GLENWOOD HIGH SCHOOL

Our Ref: AN020-215523_SINSW_Glenwood HS_SSDA_LA_V2_211013

Date: 13/10/2021

This Accessibility Report accompanies an Environmental Impact Statement (EIS) pursuant to Part 4 of the Environmental Planning and Assessment Act 1979 (EP&A Act) in support of a State Significant Development Application (SSD - 23512960).

Title
SSDA
BUILDING HJ - DEMO PLAN -
LEVEL 00
Drawing Number
DA-AR-HJ101

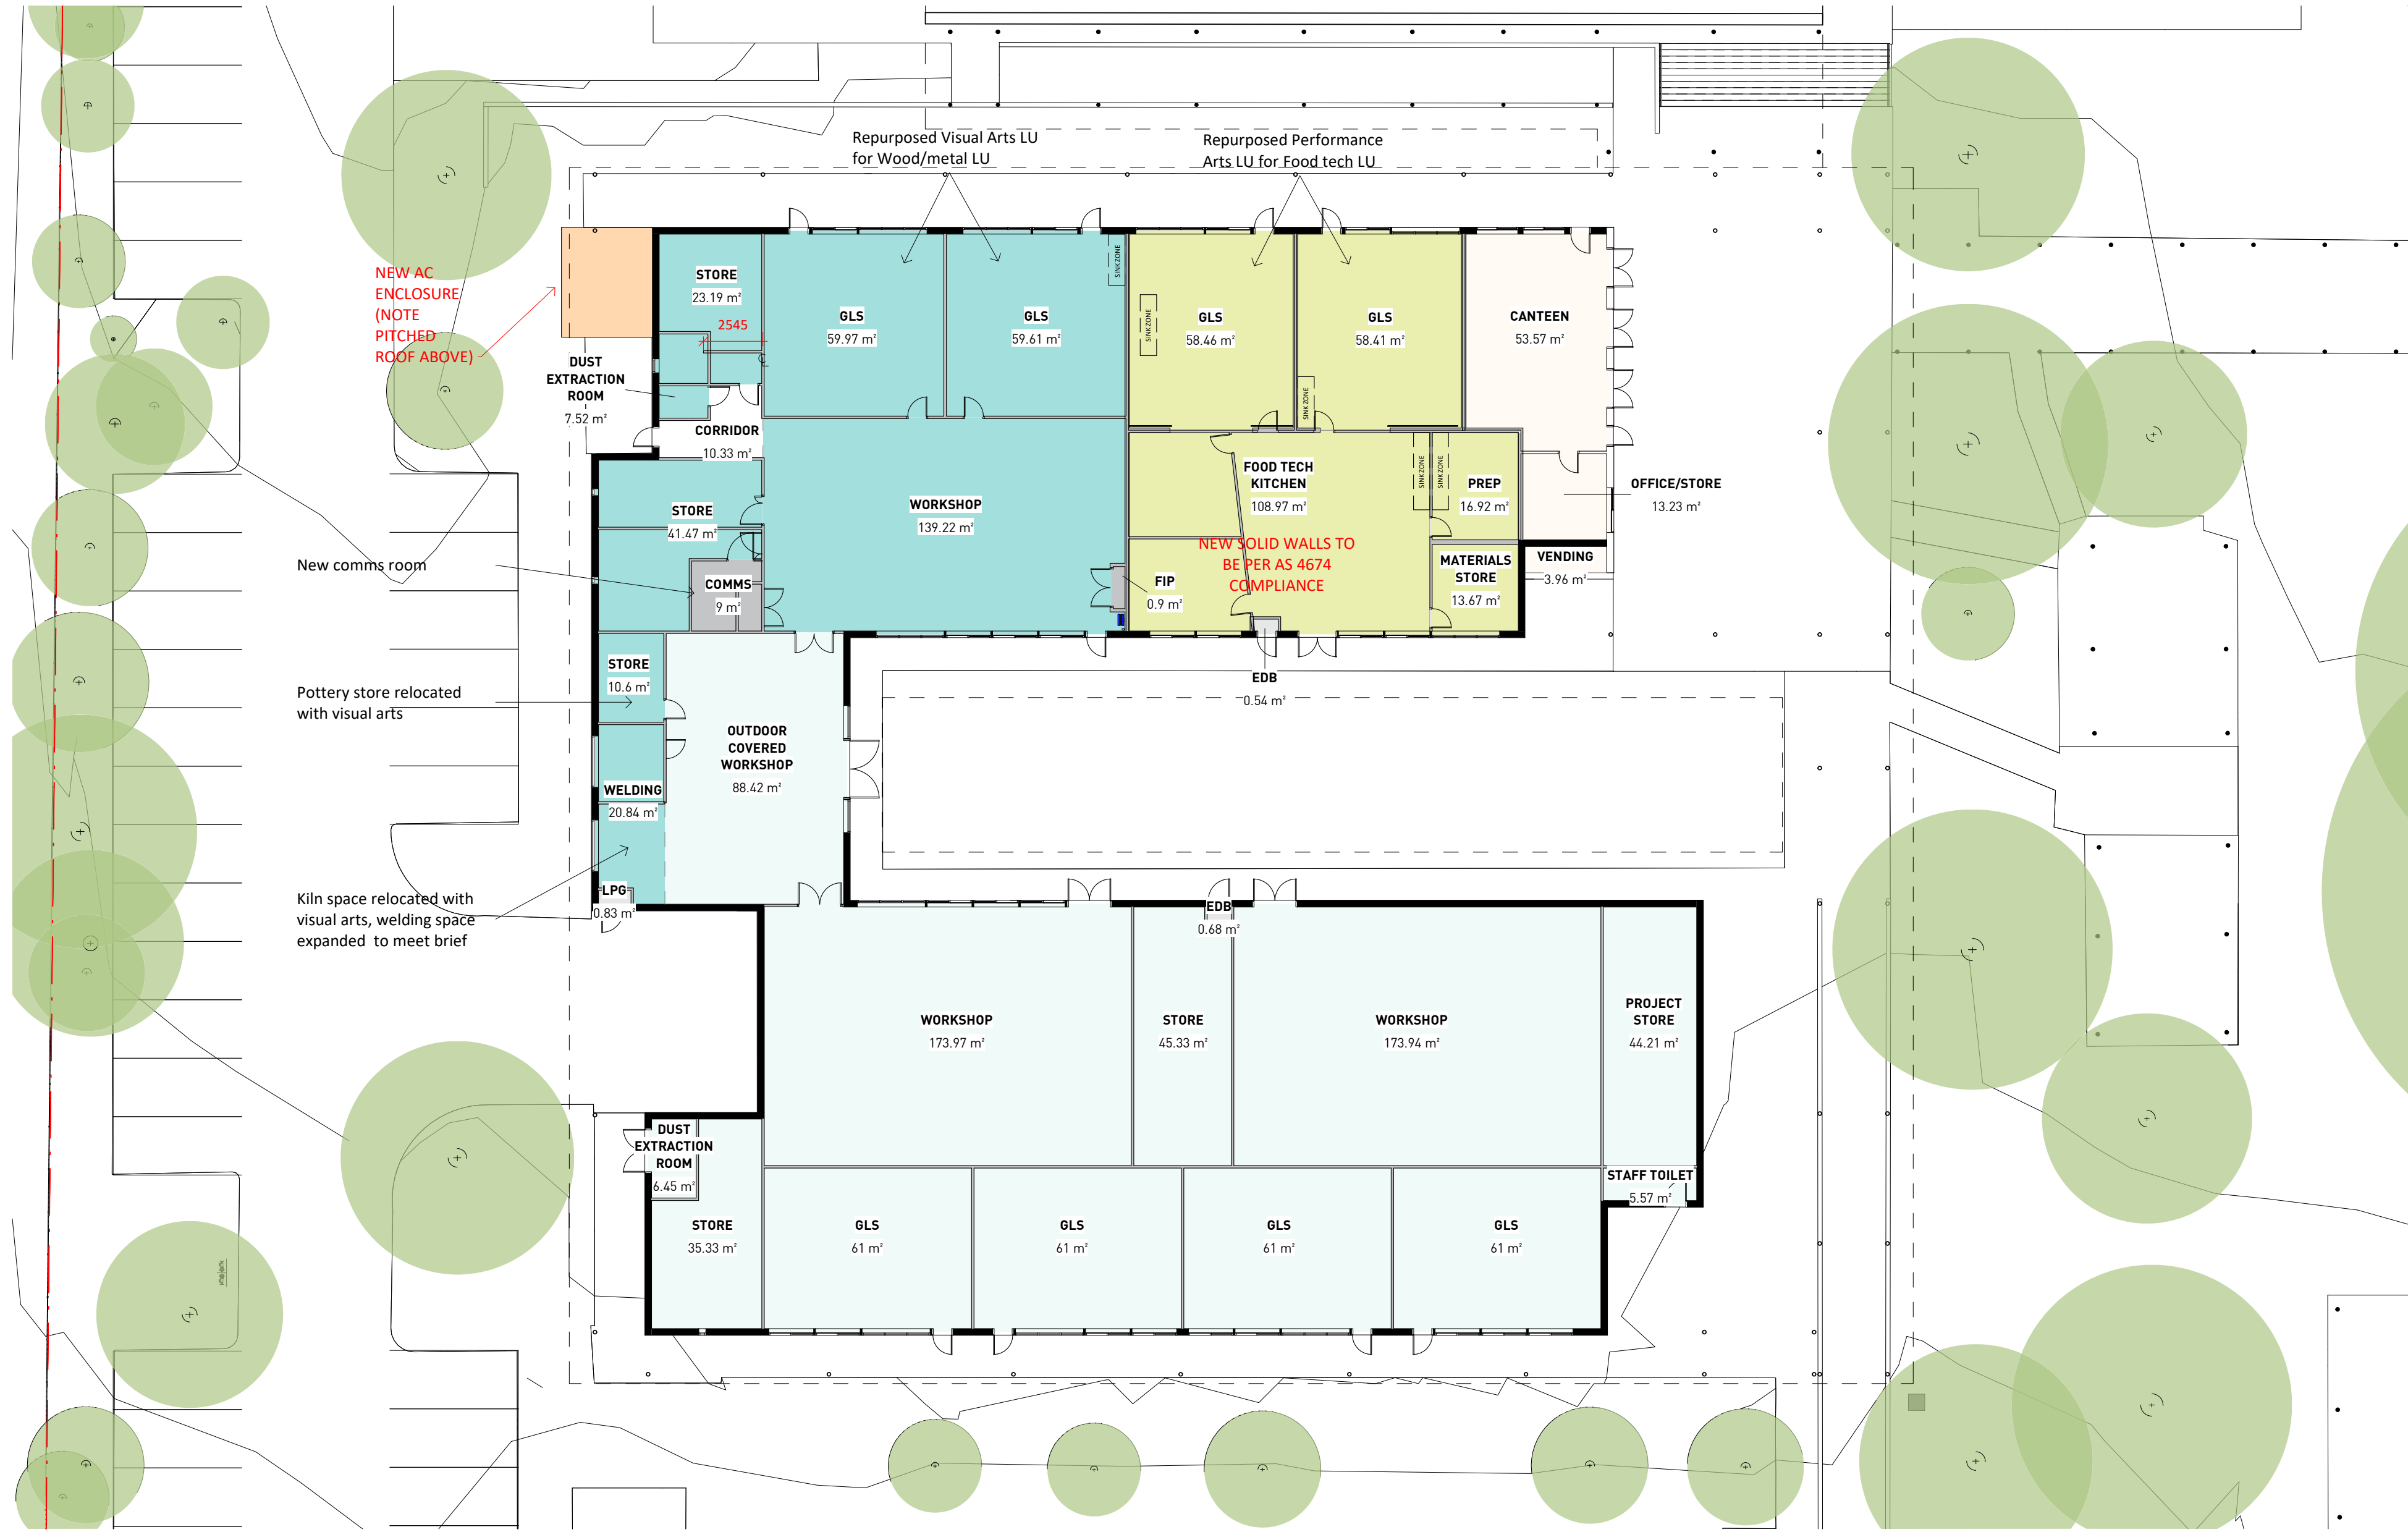
Existing buildings Block E and J with internal modifications appear to be capable of accommodating required affected paths of travel through further detailed design coordination.

Confirmation is required on the accessible pathway connecting building J and K.

For the existing buildings where internal modifications are being proposed, there are multiple doorways, which achieve non-compliant door circulation spaces these doors will need to be coordinated and to comply during subsequent design development stages.
